**PROPOSED RESIDENTIAL DEVELOPMENT, BERRY HILL ROAD, ADDERBURY (1899)
APPLICATION NUMBER 17/02394/OUT
FURTHER RESPONSE TO HIGHWAY COMMENTS – APRIL 2018**

This note will provide a further formal response to additional transport and highways comments made by Oxfordshire County Council (OCC) in relation to the above planning application for residential development on land at Berry Hill Road in Adderbury. The comments were dated on 11th April 2018.

DRAWING NUMBER: **1899-F01** REVISION: **H**

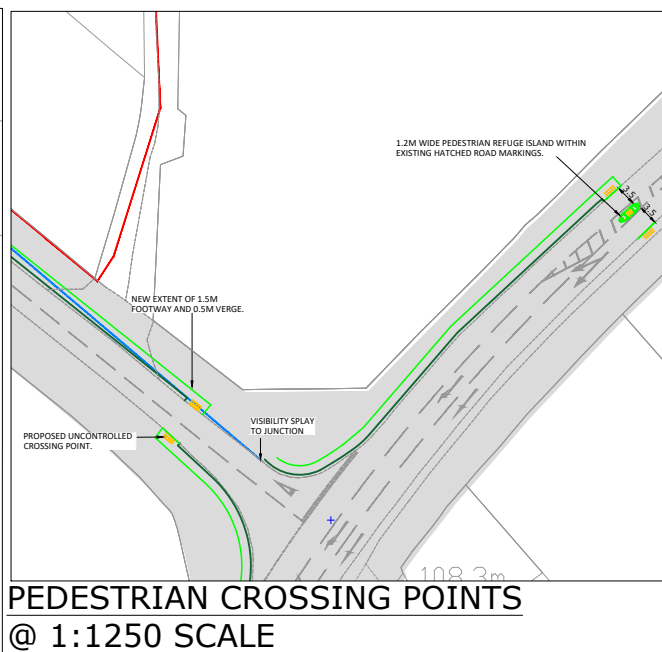
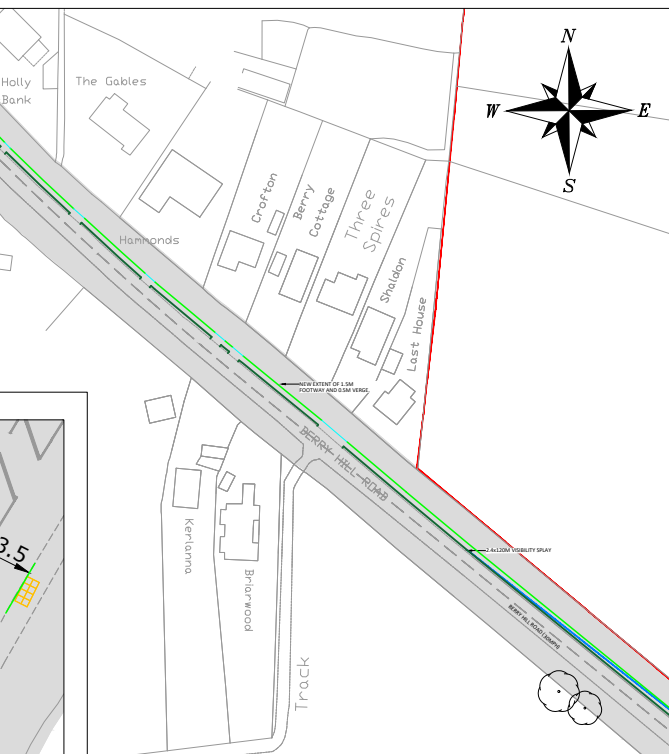
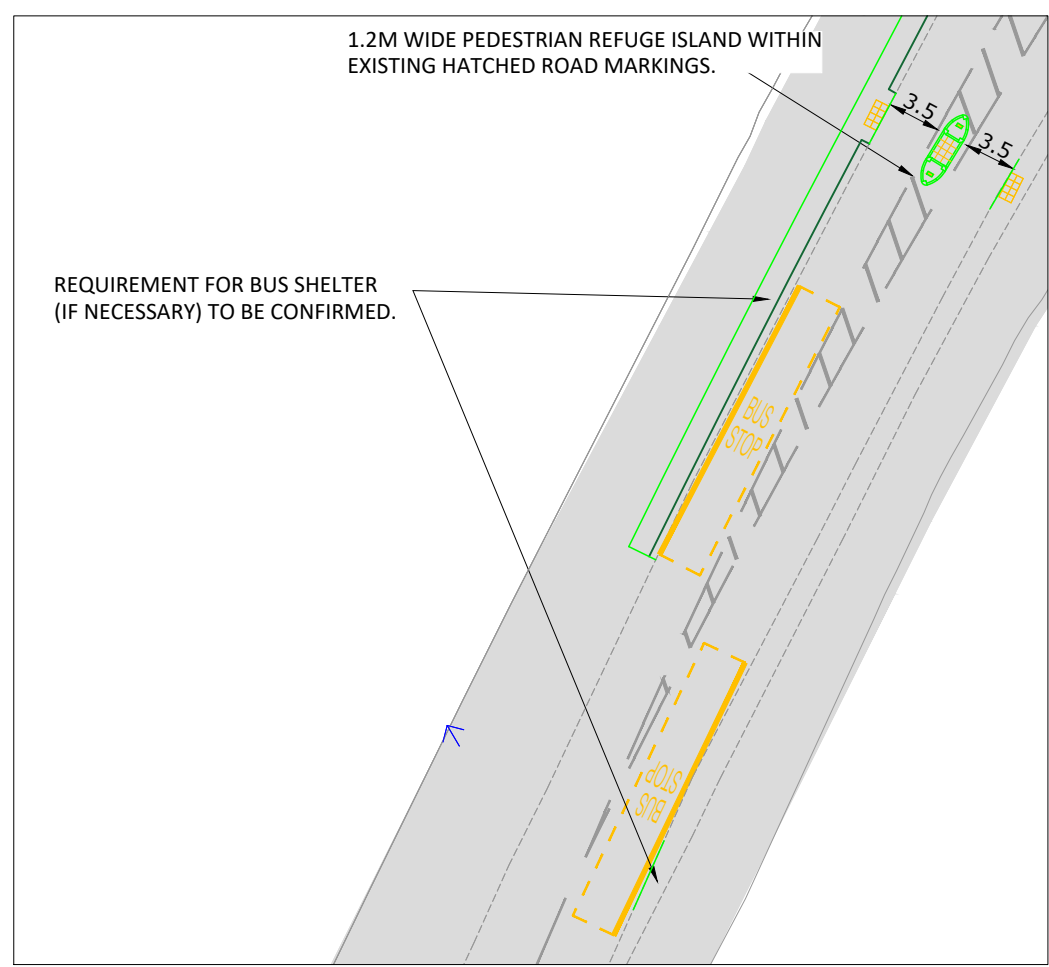
The access plan also shows a new pedestrian refuge which OCC confirm is acceptable in principle. However, they have requested that this is widened to 1.8m width. This would then mean that the running lanes on Oxford Road would be reduced down to 3.2m wide. This is likely to be too narrow given the traffic volumes along Oxford Road. The width of 1.2m would provide a useful and safe crossing facility and as such it is proposed to leave the design as it is shown on Drawing Number 1899-Fo1 Revision C as this would provide the better balance between lane widths and refuge island width.
